Our Ref: P/40/22/NMA

**Section 96A of the Town & Country Planning Act 1990 (as amended)
Town and Country Planning (Development Management Procedure) (England) Order 2015
(as amended) - Article 10**

Non-material amendment following grant of P/70/19/RES to change some brick types on the Materials Schedule to some of the dwelling plots (Plots 51-52, 86-87 and 88-89) and replace rooflights to some plots to dormer windows (Plots 51-52, 86-87 and 88-89).

Land To The West Of Pagham Road Pagham PO21 4NG

Rear Elevation

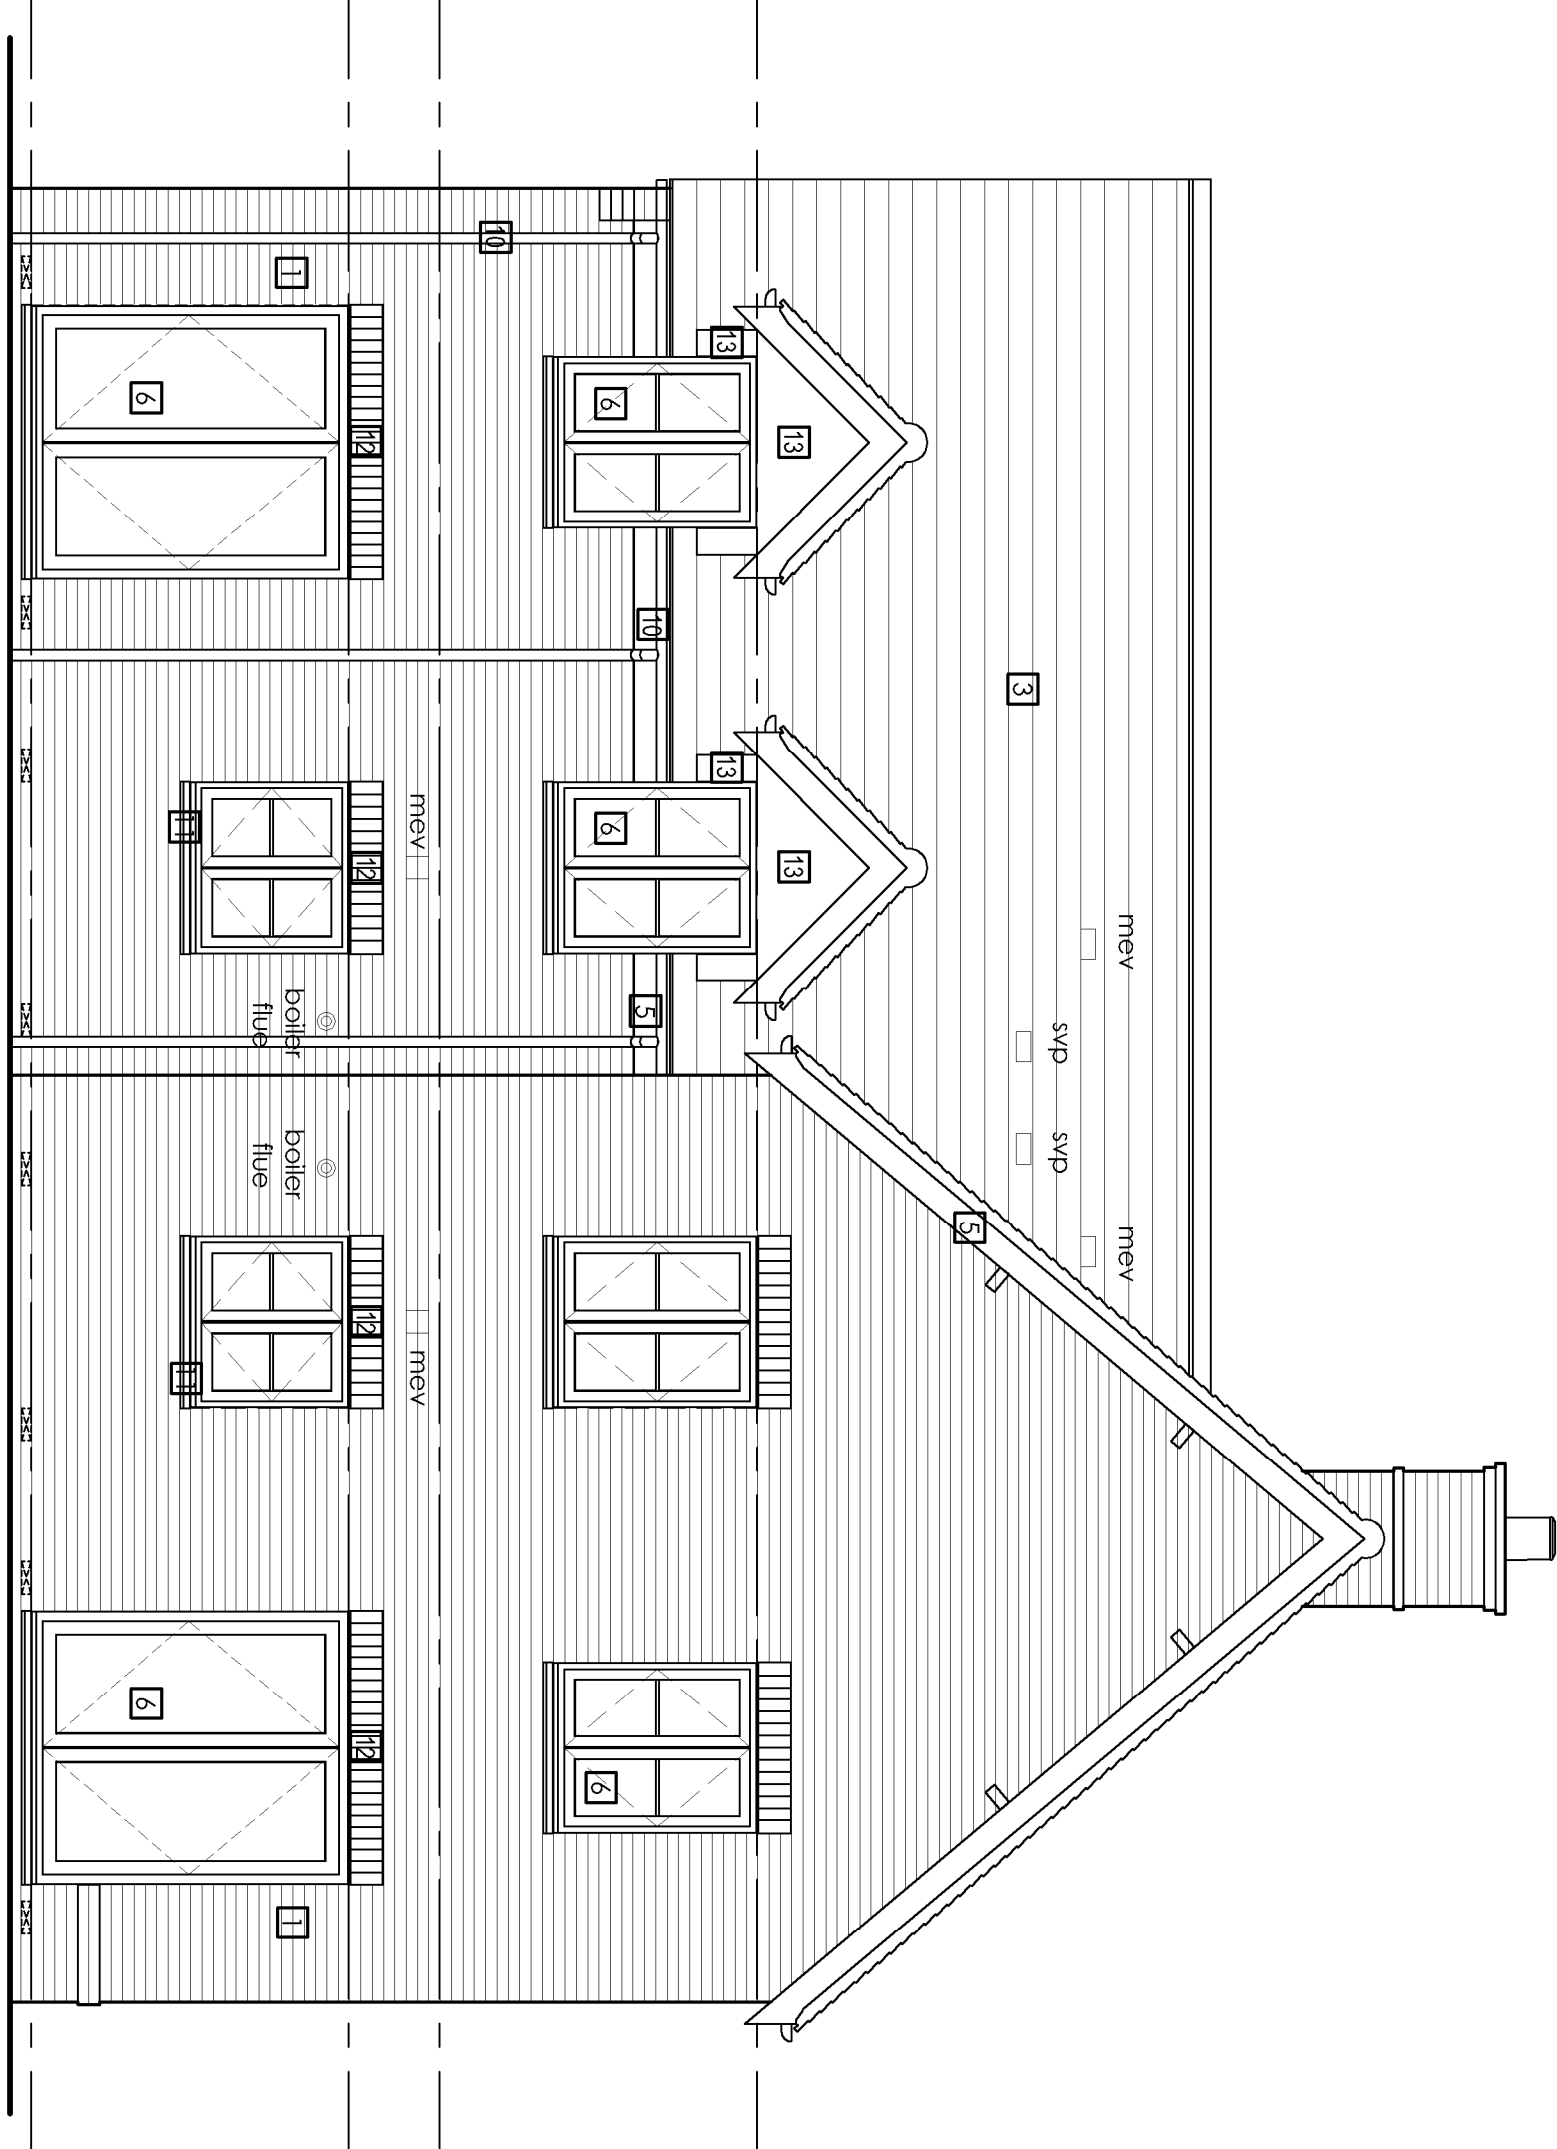
- use Ibstock Thakeham Red Multi Stock to some of the plots;
- use Vandersanden Sundridge Handmade Stock instead to some of the plots;
- replace roof lights on the fronts of the Hickstead house type (plots 51-52 & 86-89 only) with small dormers to match those already on the front and rear elevations.
